**APPLICATION BY WEST BURTON SOLAR PROJECT LIMITED**

**POST HEARING SUBMISSIONS**  
**ON BEHALF OF LINCOLNSHIRE COUNTY COUNCIL**  
**AT DL5**

Hedgerows to be removed - Sheet 4 of 4
(Change Request Version)

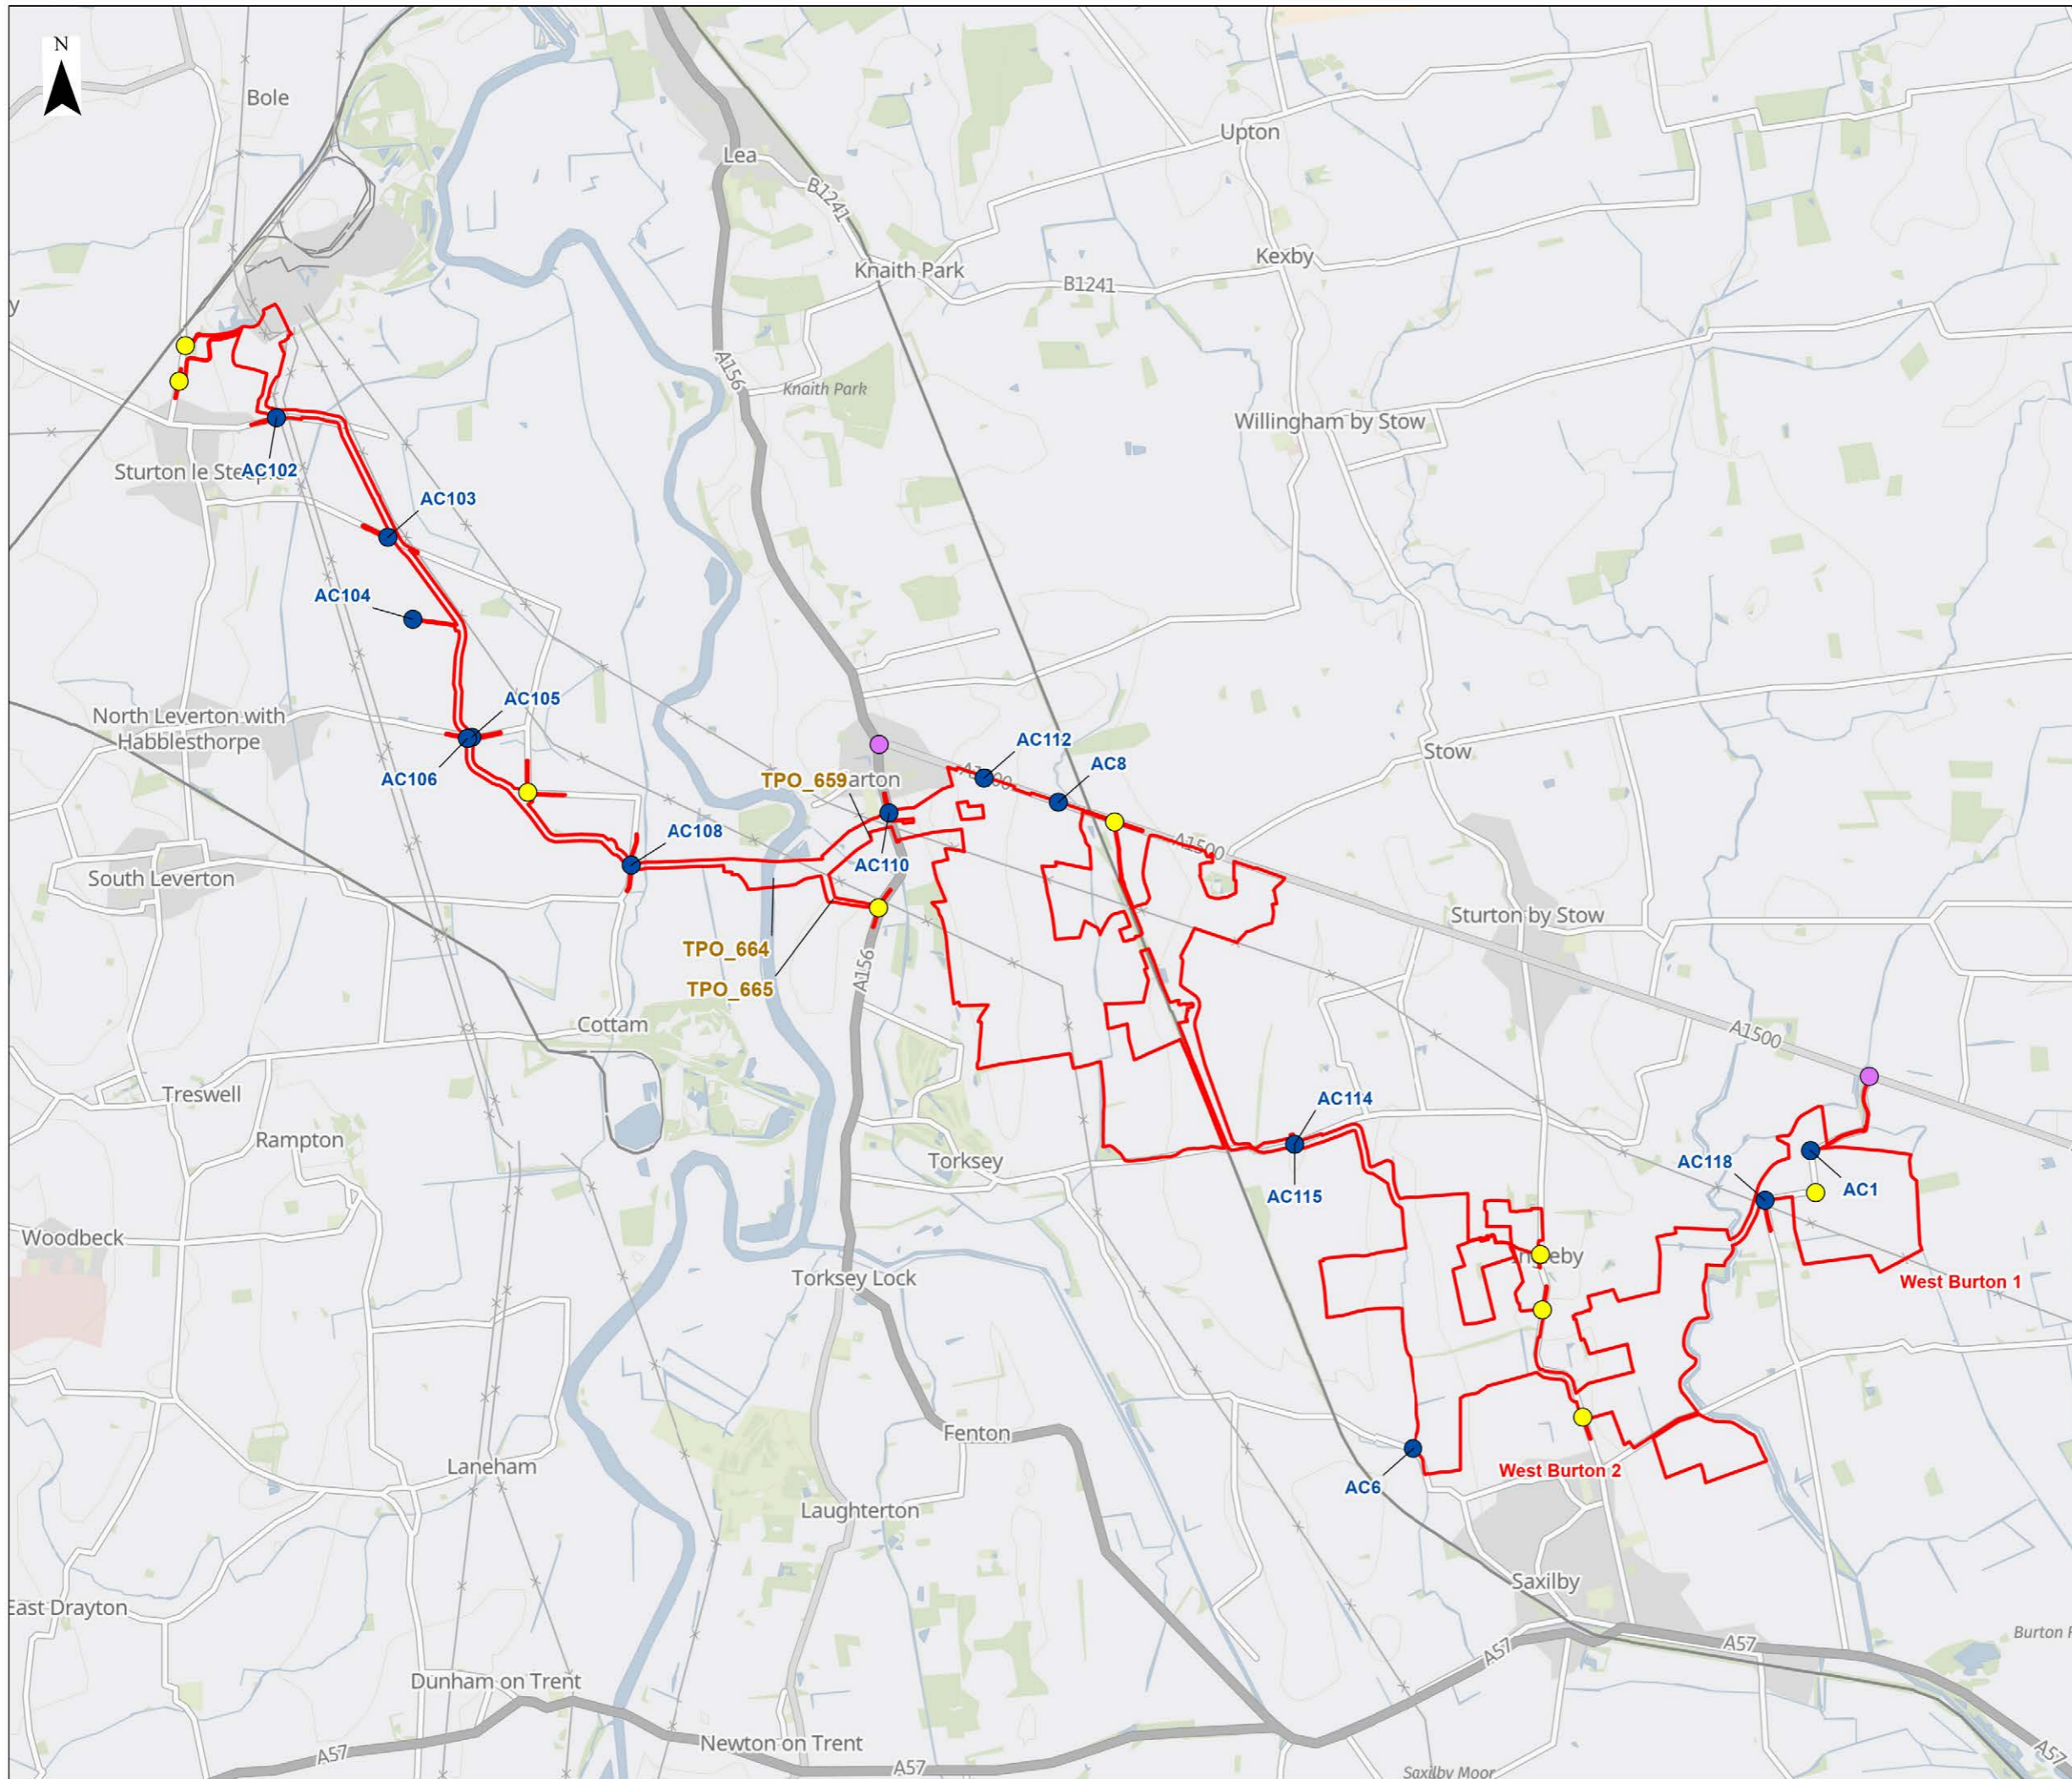
22. Whilst establishing planting will add a positive element to this landscape and vegetation removal, as shown on the Hedgerow Removal Plans contained with Appendix C of the Outline Landscape and Ecological Management Plan, is relatively minimal, this is in the context of extensive change to land use over a large area, affecting the current sparsely settled and quiet agricultural character, which is currently unprecedented in the county in terms of scale. LCC has considered whether the secured mitigation balances out the change but concluded that the urbanising element in rural agricultural land is a definite, significant and adverse change. Mitigation planting goes some way to reduce this but the result is an adverse impact.
